# Rosefield Solar Farm

## Notification of Proposed Change

EN010158/APP/8.15  
Revision 01  
May 2026  
Rosefield Energyfarm Limited

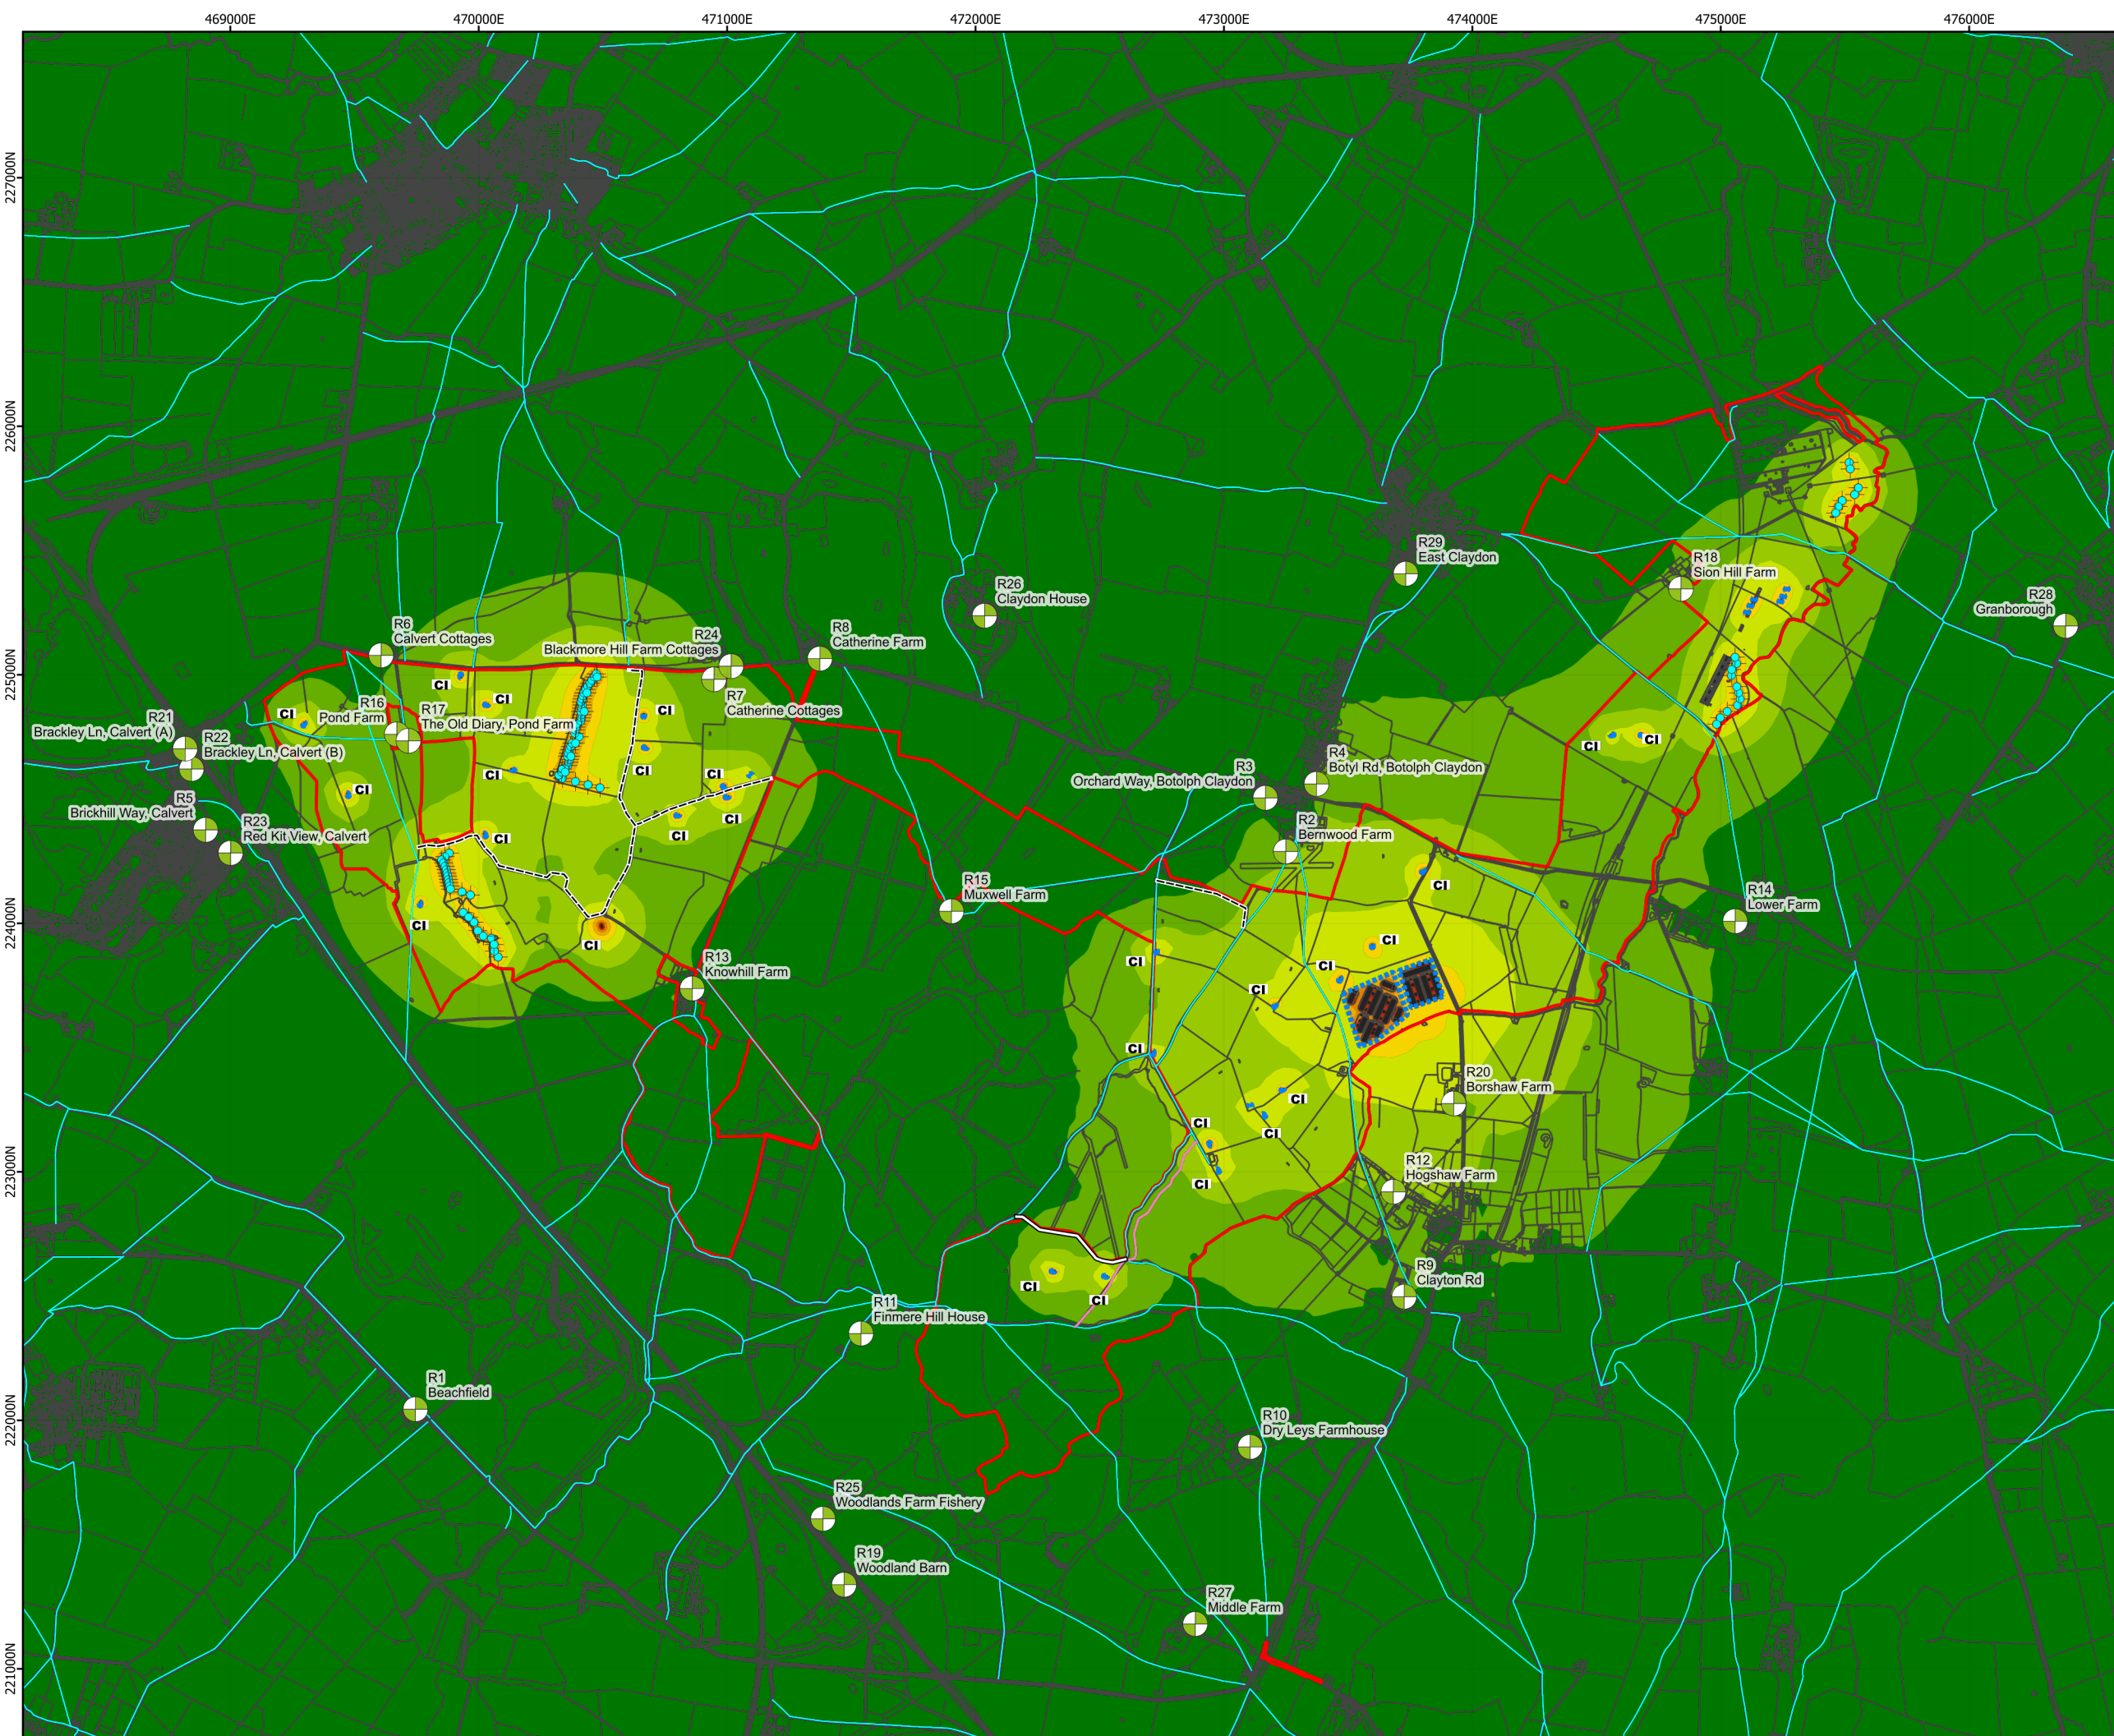
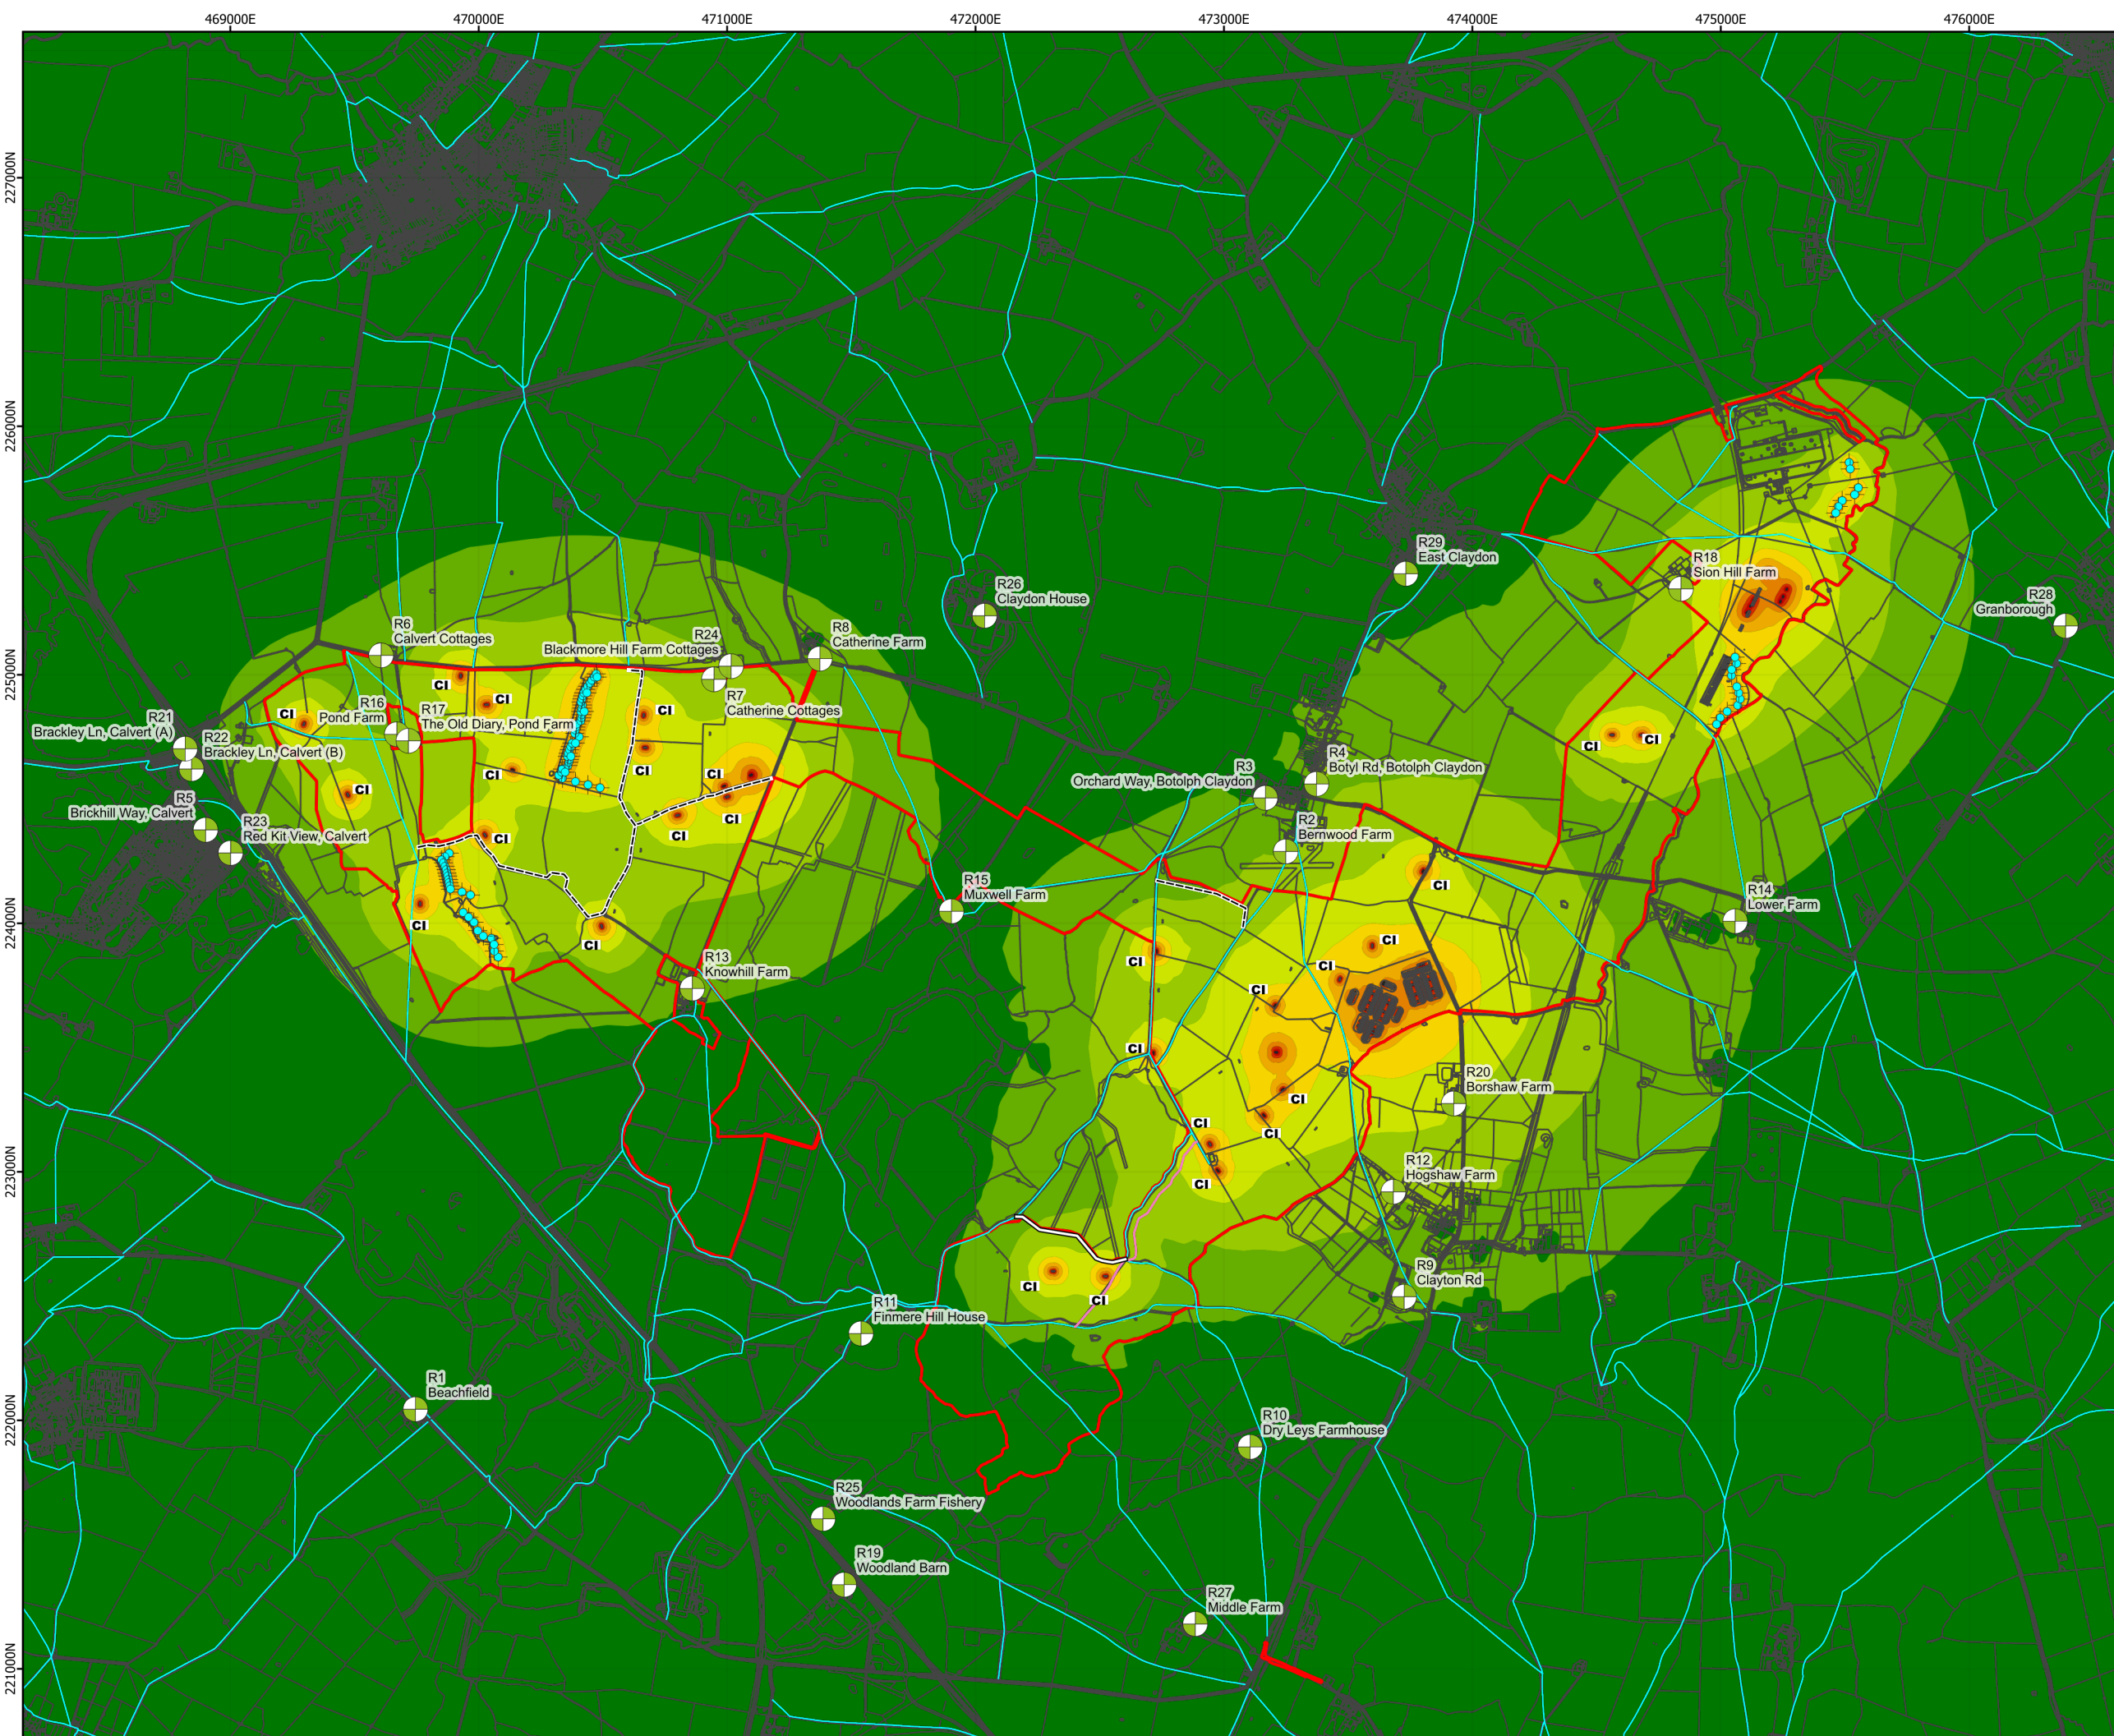
- 3.1.3. Given that the Proposed Change provides a clear benefit to the Proposed Development, no substantive amendments are required and no changes are required to the Environmental Impact Assessment, other than minor updates to acknowledge this additional route within the **ES Volume 2, Chapter 14: Population [EN010158/APP/6.2.2] [REP2-033]** and illustrated in **ES Volume 3, Figure 13.3: Operational Phase Noise Contours (without additional mitigation) [EN010158/APP/6.3.2] [REP2-040]** and **ES Volume 3, Figure 13.4: Operational Phase Noise Contours (with additional mitigation) [EN010158/APP/6.3.2] [REP2-040]**.

Plate 7.2: Proposed PRoW diversions, and permissive paths and illustrative alignment of the proposed bridleway link (the northern section would be a permissive path and the southern section and existing PRoW with a temporarily changed use as explained in paragraphs 5.1.5-5.1.6) in Parcel 2

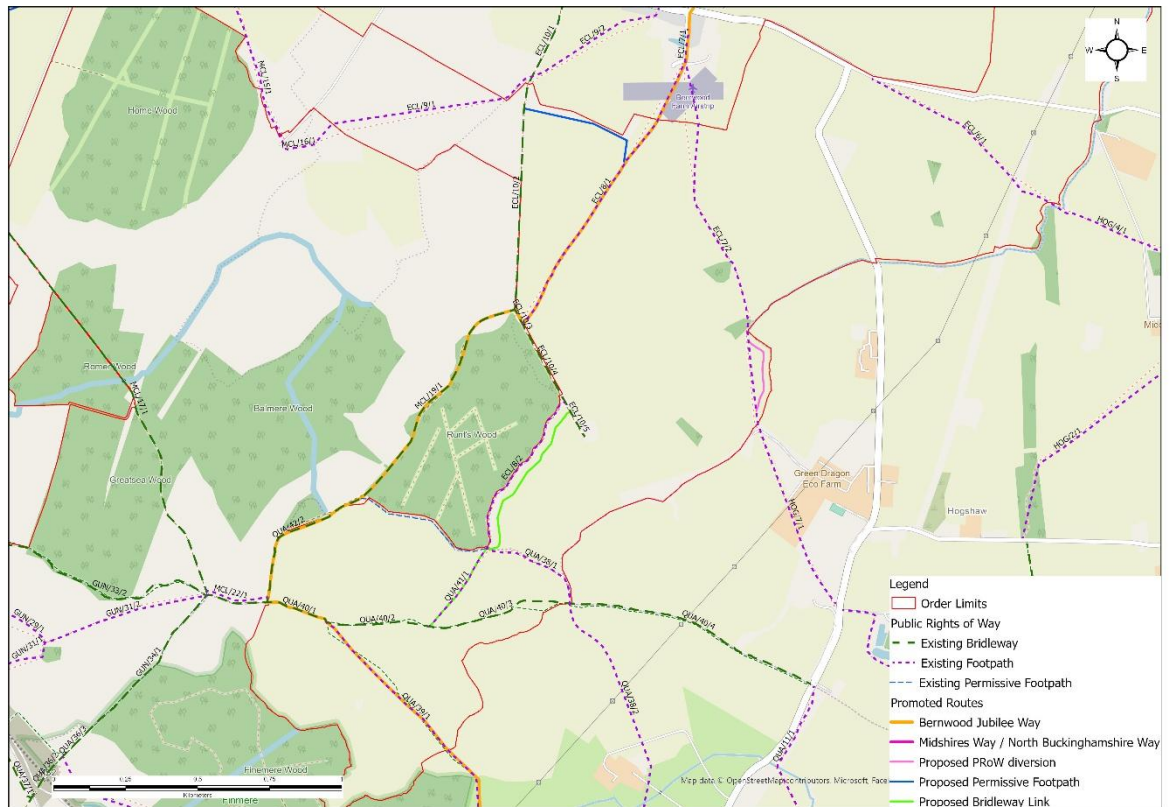
- 2.2.1. The Proposed Change would deliver a bridleway link across Parcel 2, which would be accessible to the public during the operation (including maintenance) phase of the Proposed Development. It would connect the existing dead-end PRow Bridleway (reference 'ECL/10/5') to the north of Field D27 to the PRow Bridleway (reference 'QUA/40/2' and 'QUA/40/3') that runs along the southern edge of Fields D28 and D29, addressing the “missing link” in the bridleway network identified by Buckinghamshire Council. Please refer to Appendix A of this document for a plan showing the location of the Proposed Change.

- 2.2.2. The proposed bridleway link would run south west along the proposed internal access track through Field D27 and then along PRow Footpath (reference 'QUA/41/1') through Field D28. The total distance of the link would be approximately 0.9 km long, of which 0.3 km follows the alignment of PRow Footpath reference 'QUA/41/1'.
